About the application

Application number: 2023/93796	
What is the application for?:	Erection of industrial building
Address of the site or building:	Flush Mills, Westgate, Heckmondwike, WF16 0EN
Postcode:	WF16 0EN

| Drawing Title: Proposed Site Sections               |                       |                        |    |

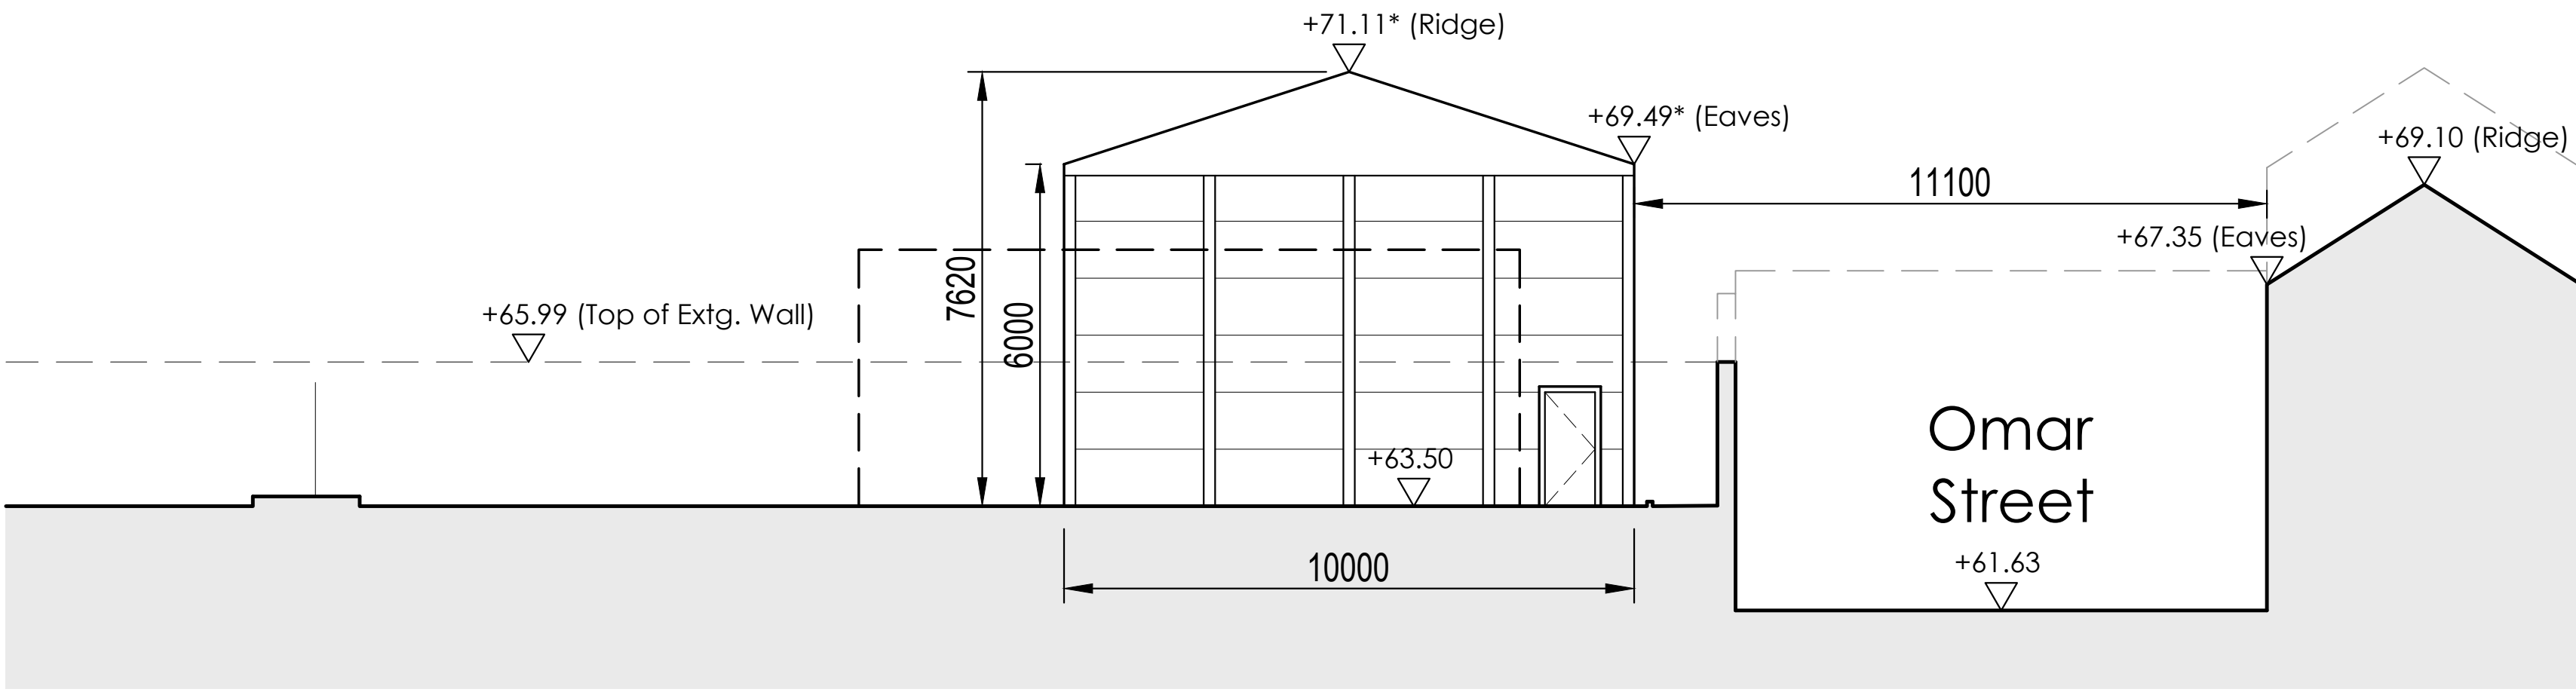
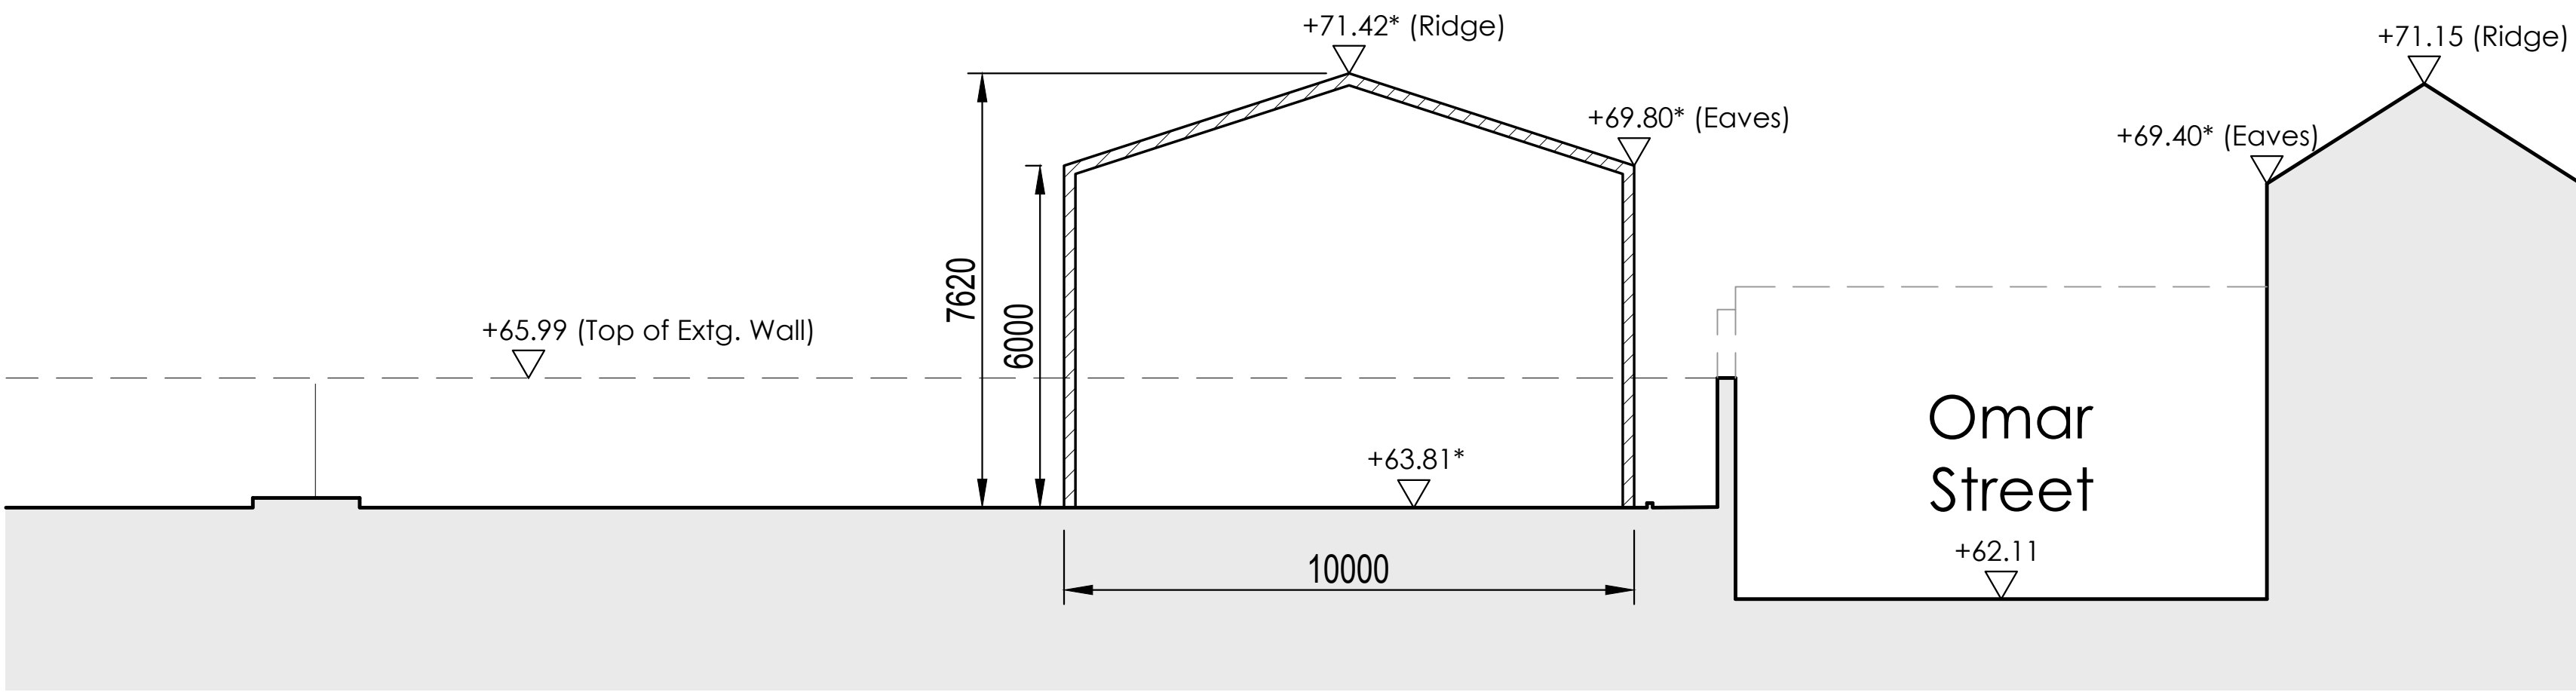
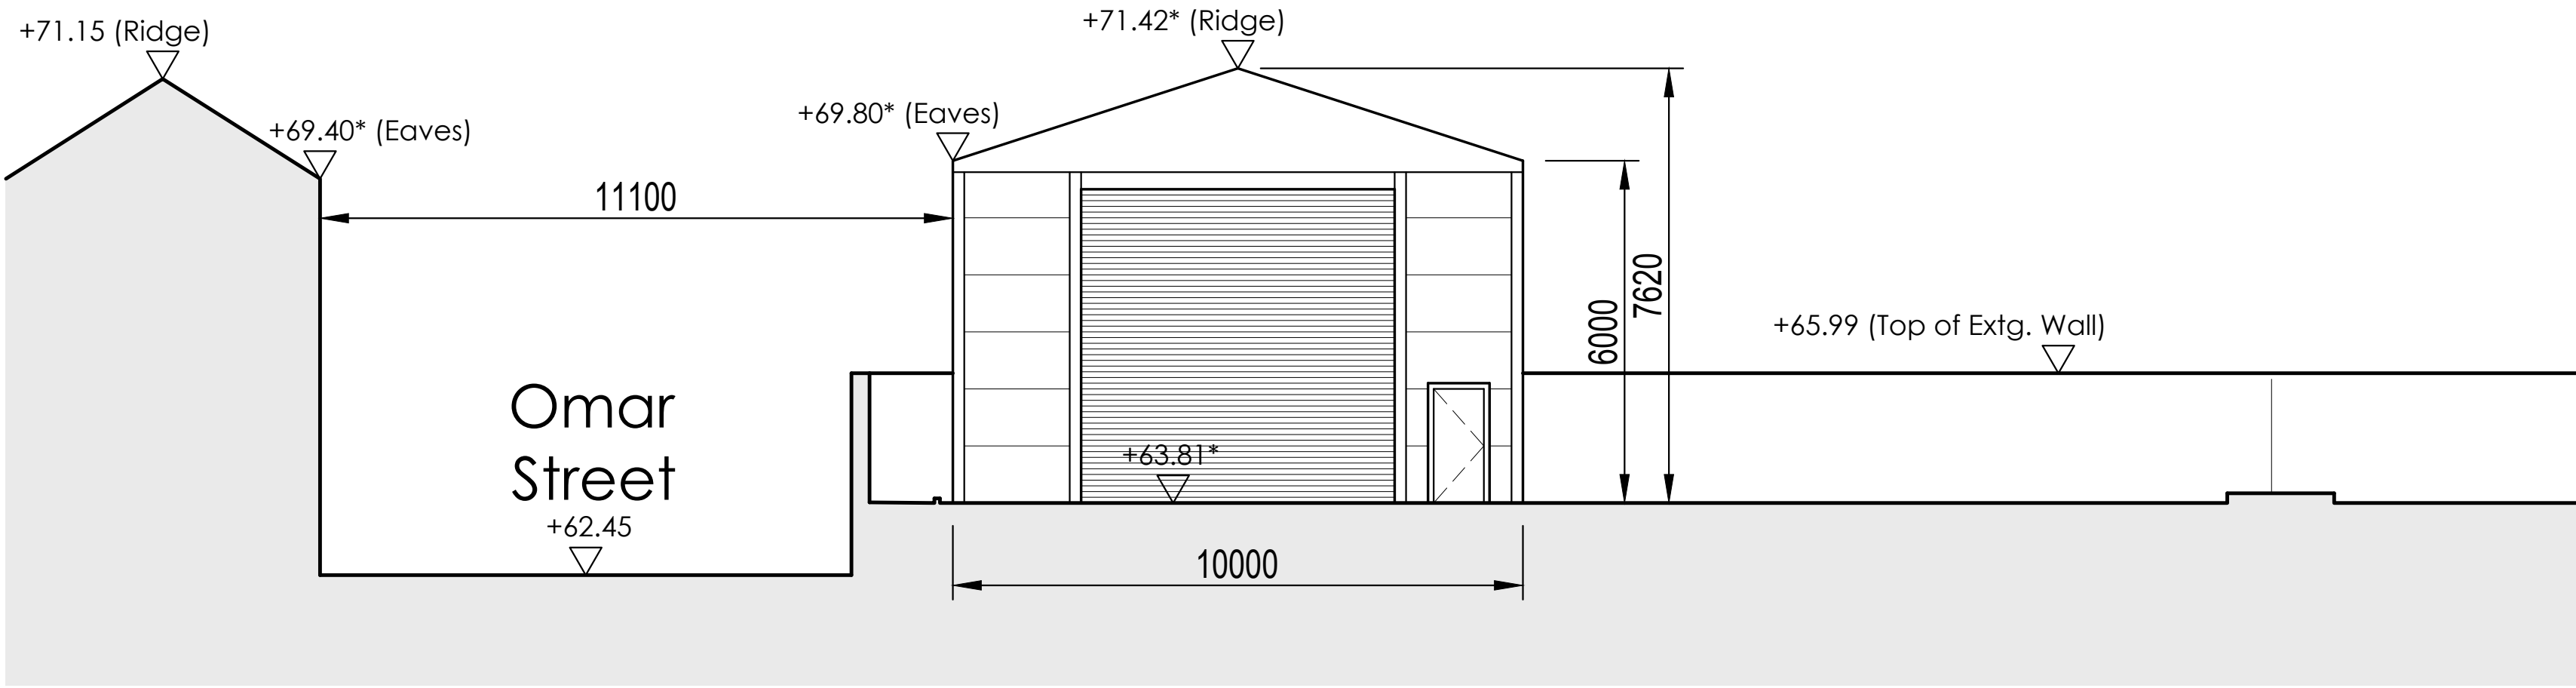
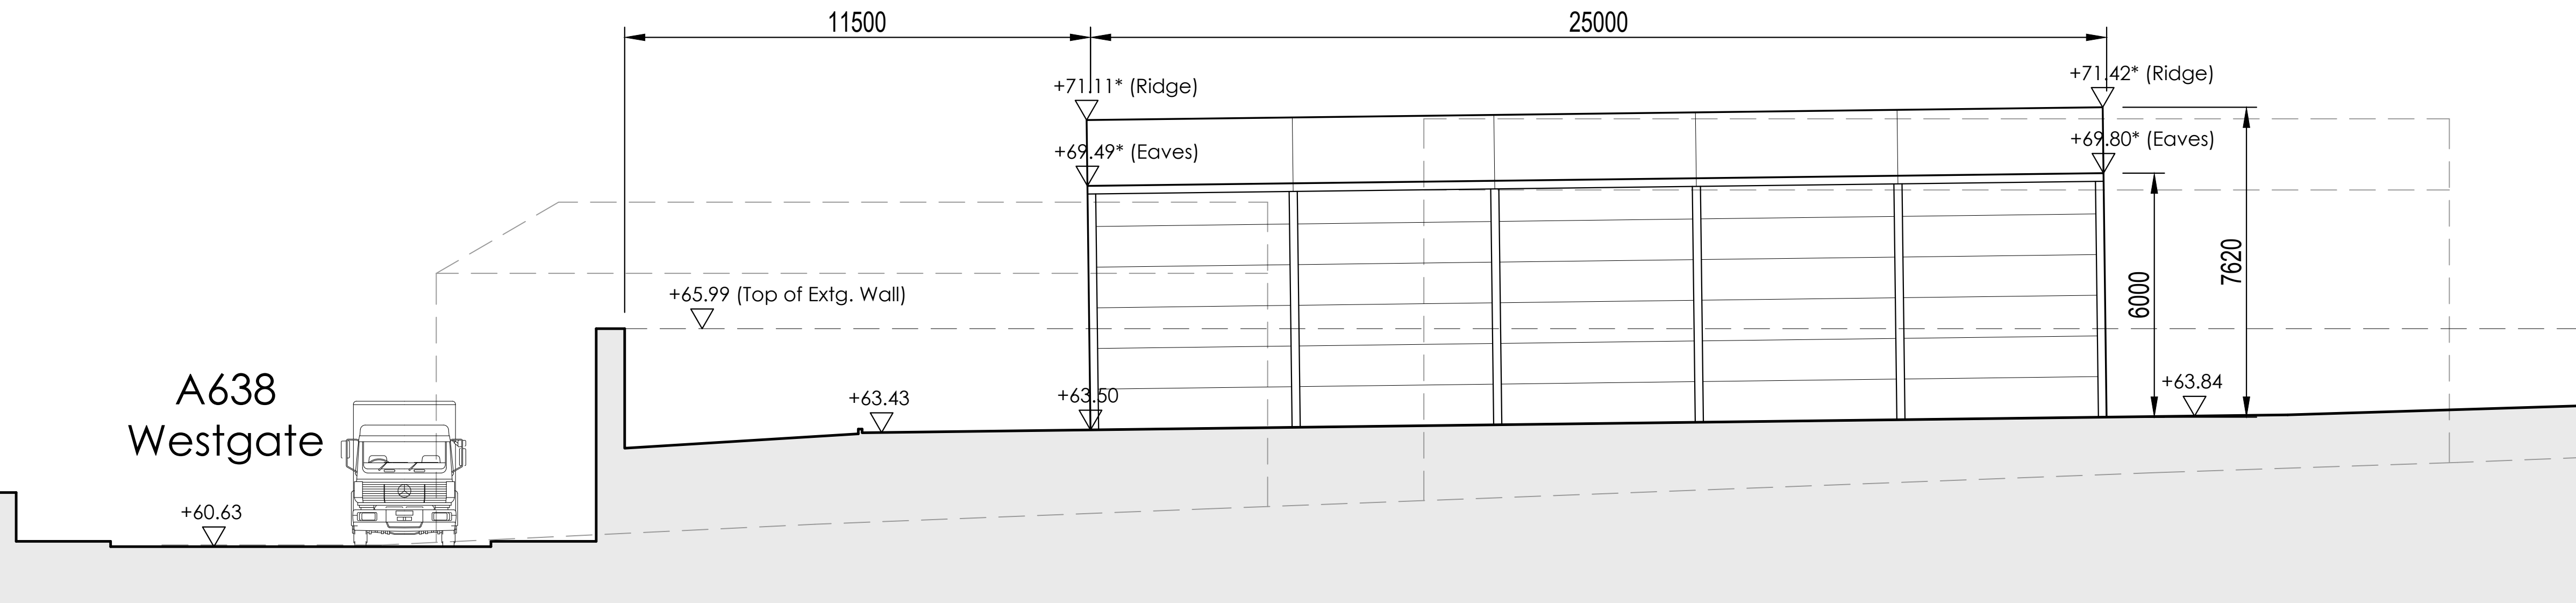
Type of comment: An objection	
Do you wish your comments to be published on the website anonymously?	Yes
This building will over view Omar street to the point of much less light to an already low light street the noise level already from the container builds in flush mills is to high level now from 6/6,30 am forklifts revving engines and moving about with reverse beacons sounding. This is not a development that is wanted so close to homes .
